NORFOLK BOREAS PLANNING INQUIRY, CAWSTON PARISH COUNCIL SUBMISSION FOR DEADLINE 6.

Cawston Parish Council wishes to submit the following for Deadline 6. This includes comments on D5 documents responding to the ExA's written questions.

CAWSTON VILLAGE CENTRE - B1145
SCALE - 1:500

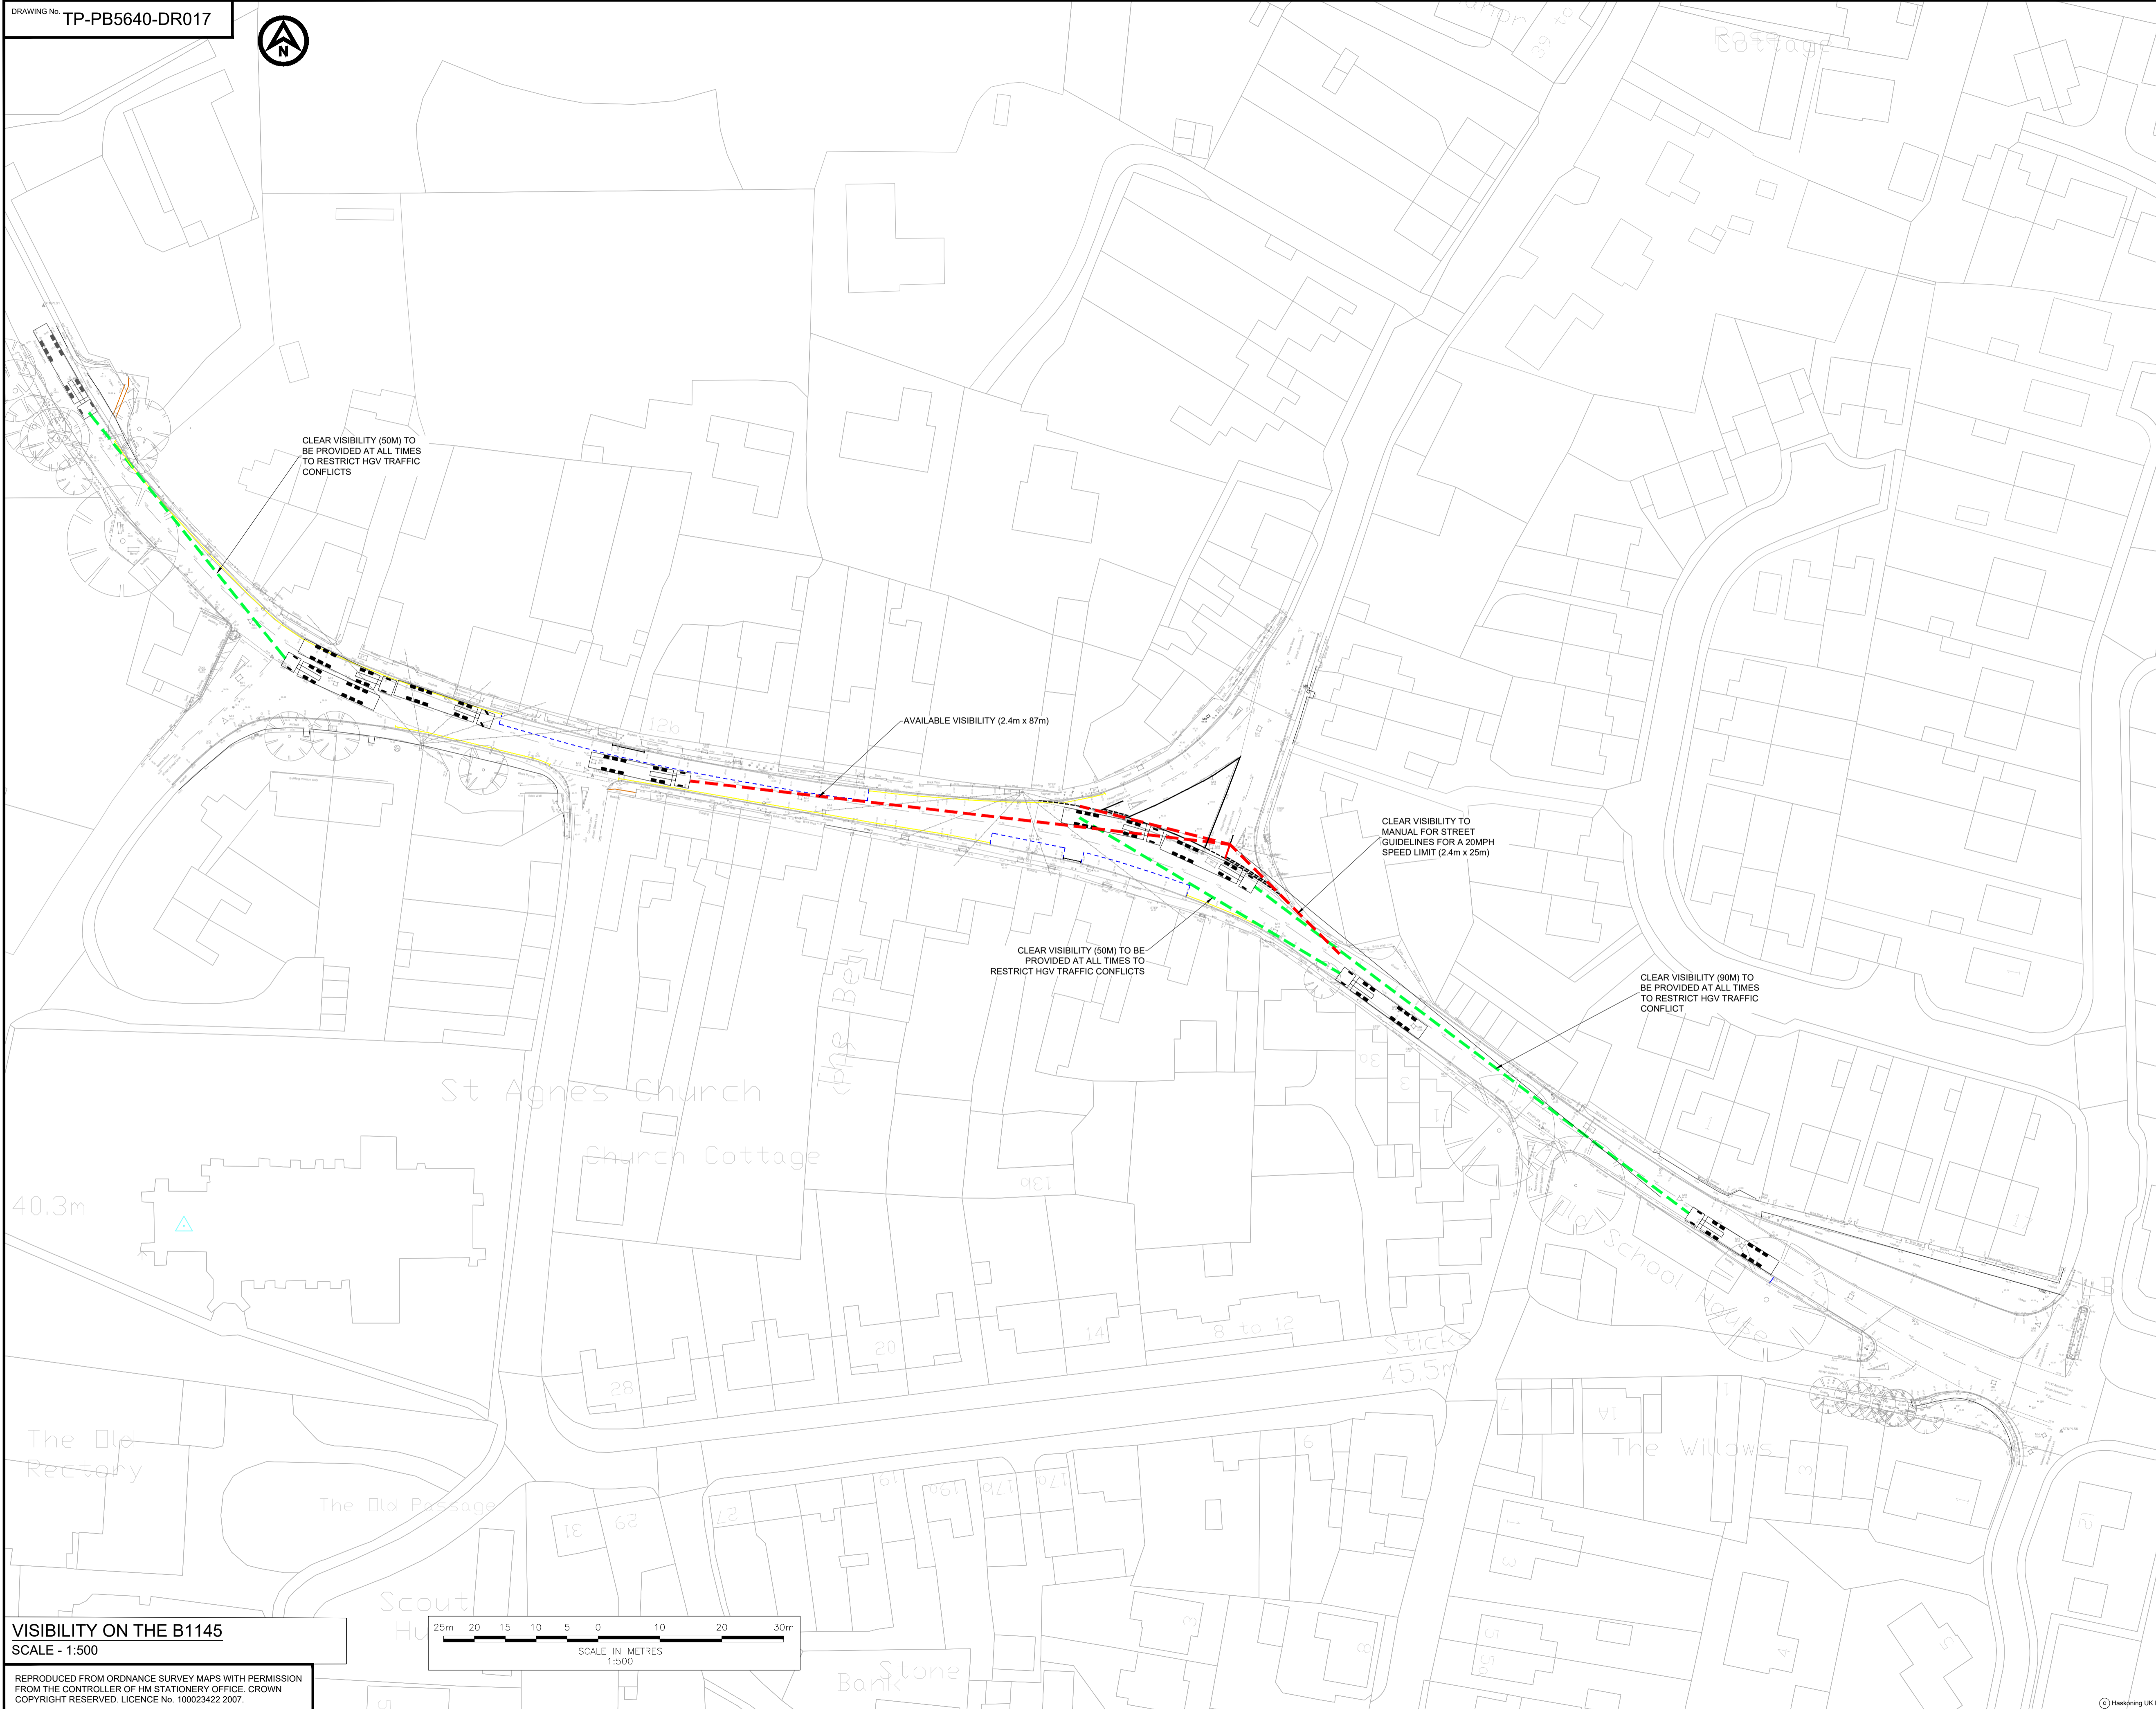
However, we maintain our position that the centre of Cawston village is unsuitable for such traffic at any time.

In our view, this is too little, too late. Given the history of the HIS it is difficult to envisage what new and effective mitigation measures might be discovered that have not already been proposed and rejected. Shutting the stable door after the horse has bolted is never a good approach.

This suggests that the Applicant's reliance on a 20mph speed limit as an effective mitigation is misplaced.

- a) The RSA confirms our points about dangers arising from sending this traffic through the centre of the village, due to the narrow road and pavements.

- h) Walking at 4km per hour (2.5 mph) a pedestrian covers 133 metres in two minutes. This means that every pedestrian can expect to encounter at least one of the Applicant’s HGVs as they walk through the village.

Cawston Parish Council’s assessment is that pedestrians’ perception – and their real experience - will be one of extreme danger. Even if they avoid physical injury, quality of life and mental health will suffer.

The geometry of Cawston High Street has remained unchanged for 250 years; if it was ever a “main distributor route”, that would have been for horse drawn traffic. It is time for the applicant to acknowledge this reality and to divert construction traffic away from the B1145 in Cawston. No more time should be wasted trying to “prove” that the next version of the applicant’s ever changing Highway Intervention Scheme could produce effective mitigation for the acknowledged hazards to people and property in the centre of our village.
